**Consultation Response from KC,  
Trees**

**2024/91451 88, Shirley Road, Gomersal, Cleckheaton, BD19 4ND**

**Erection of detached dwelling with associated external alterations and erection of front dormers including roof alterations to form first floor accommodation, installation of solar panels and external alterations to 88 Shirley Road**

**Date Responded: 18/06/2024**

| Title: - Tree Information Plan | |

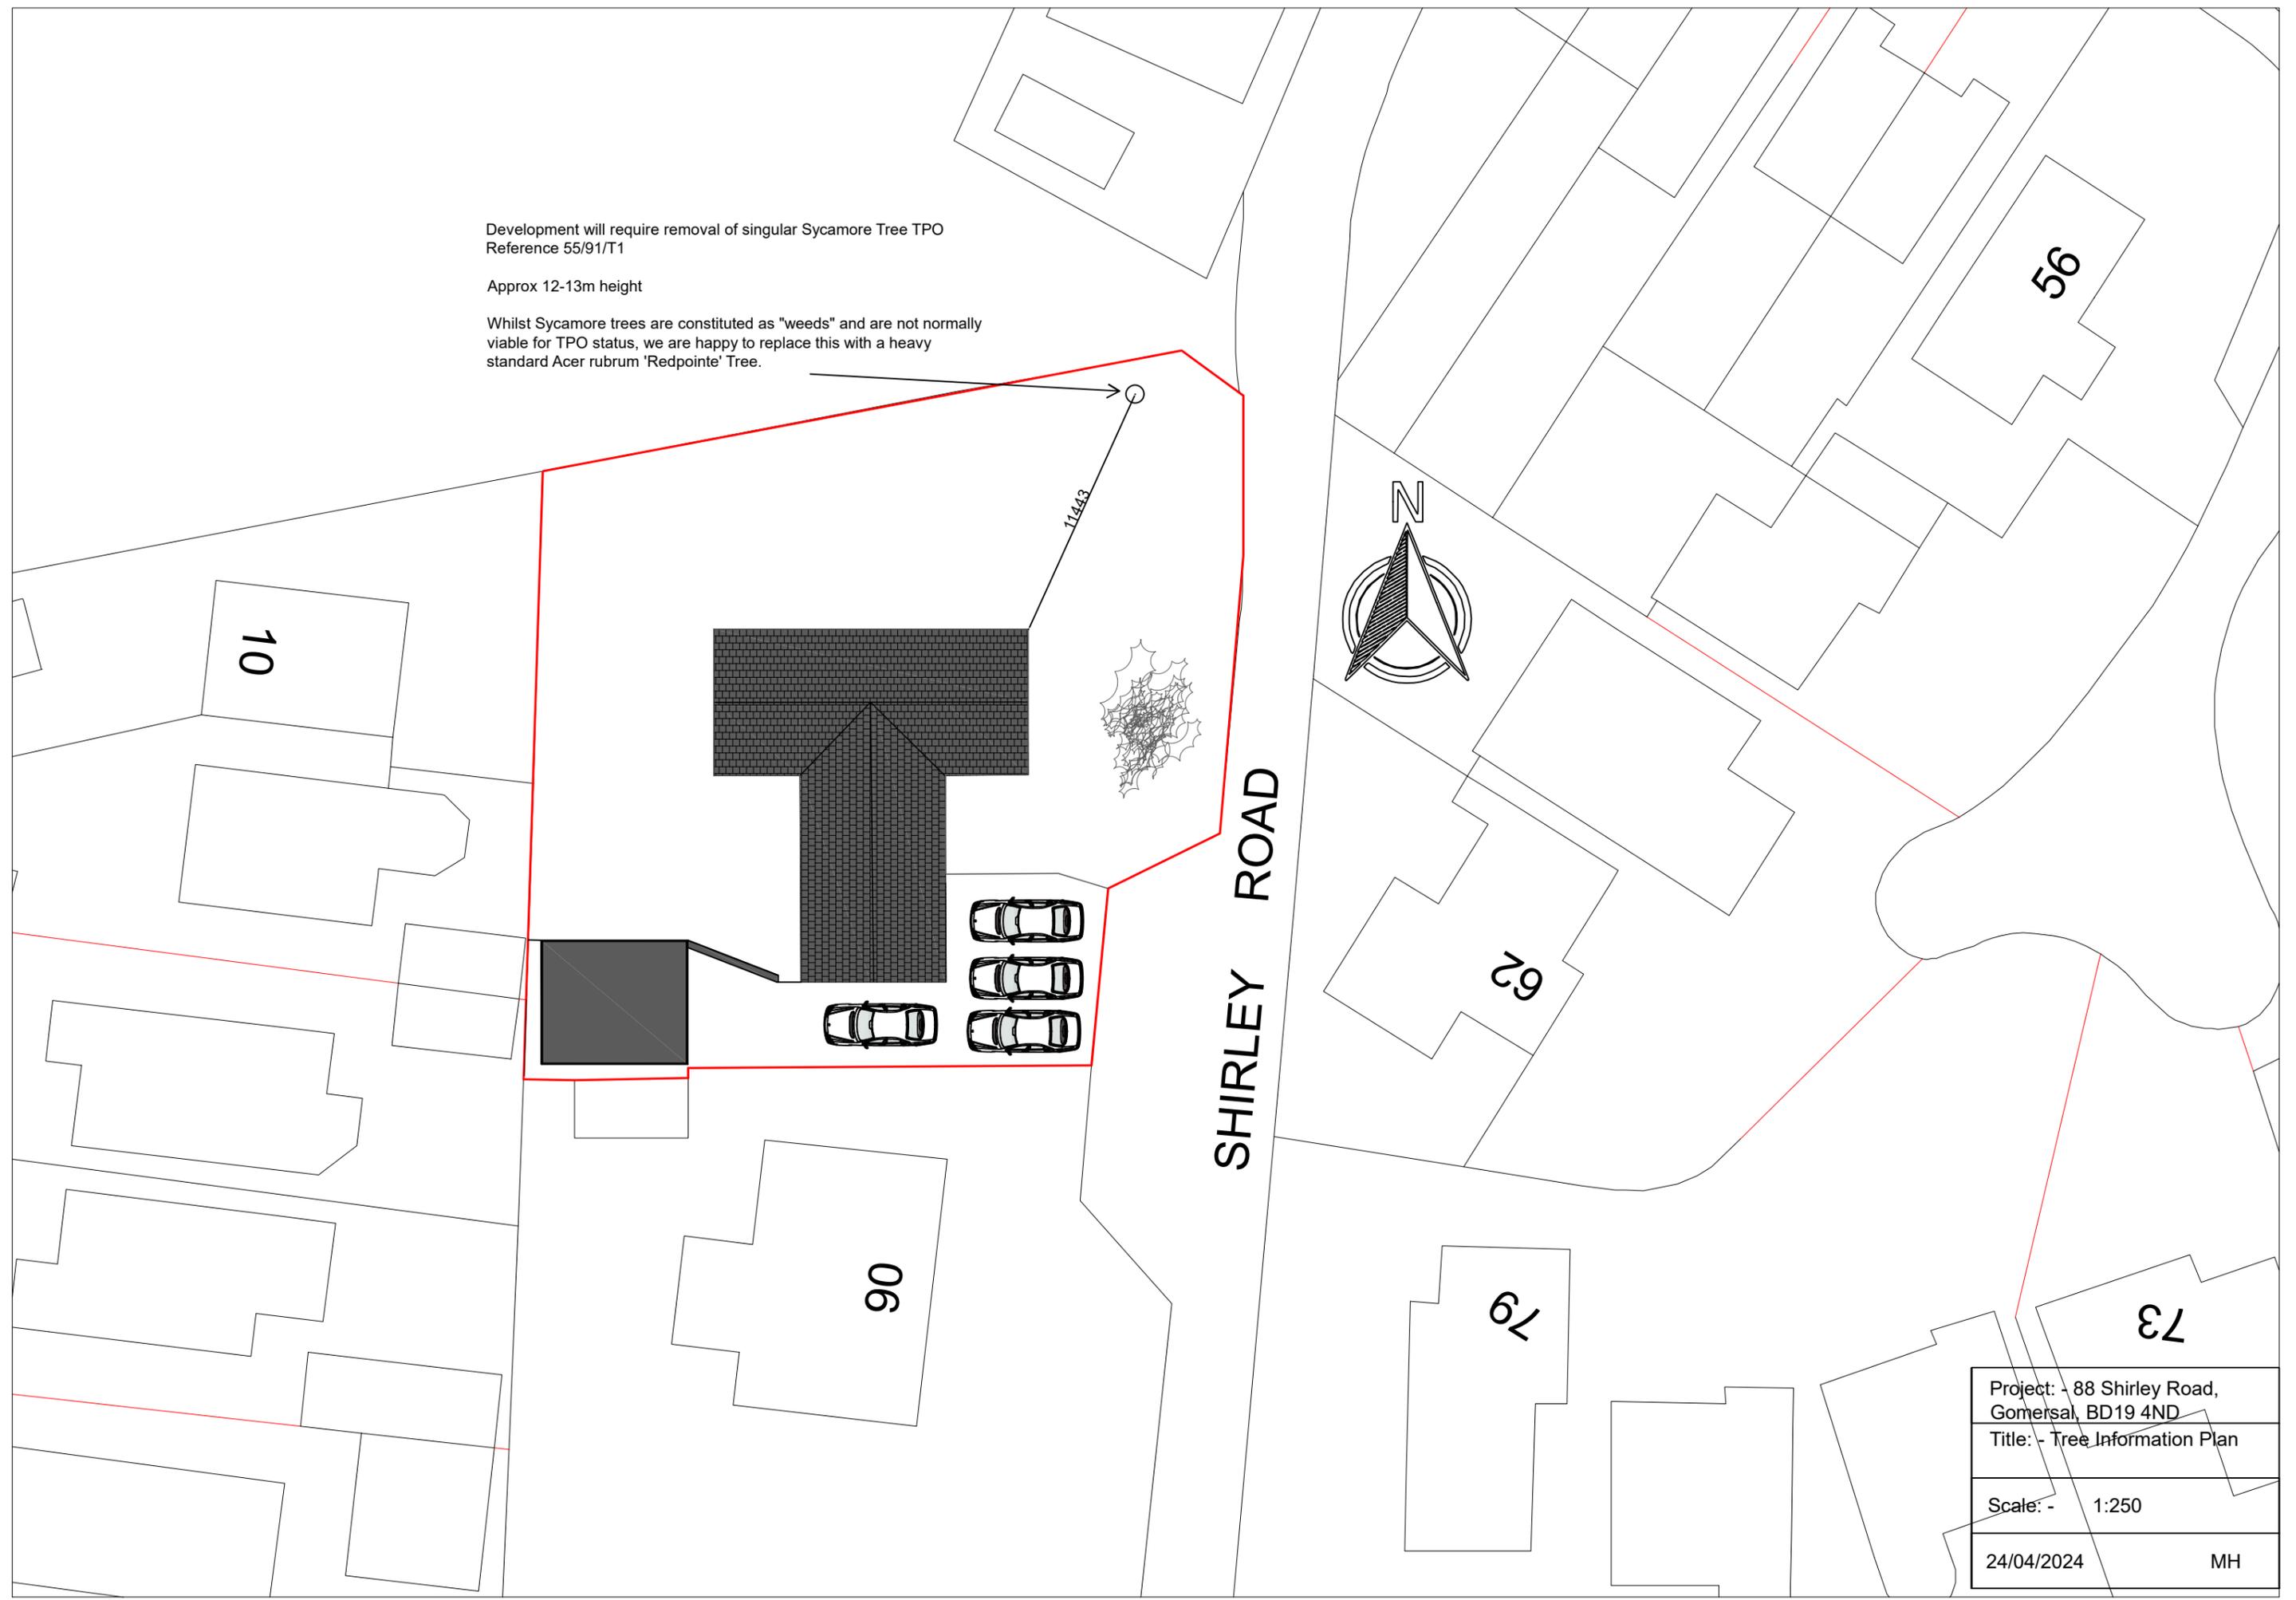
There is a tree which is Protected under a Tree preservation order (TPO 55/91) to the North East of the site.

The proposed development directly impacts this tree by suggesting it's removal purely to facilitate the proposals. Even though replacement planting is suggested this would not mitigate the loss of a mature sycamore tree and the amenity value it provides to the wider area. Its removal would also have a detrimental effect on the wider landscape.

There is an objection from a trees perspective. The proposal conflicts with adopted Kirklees local plan policy 33 and 24 (i).
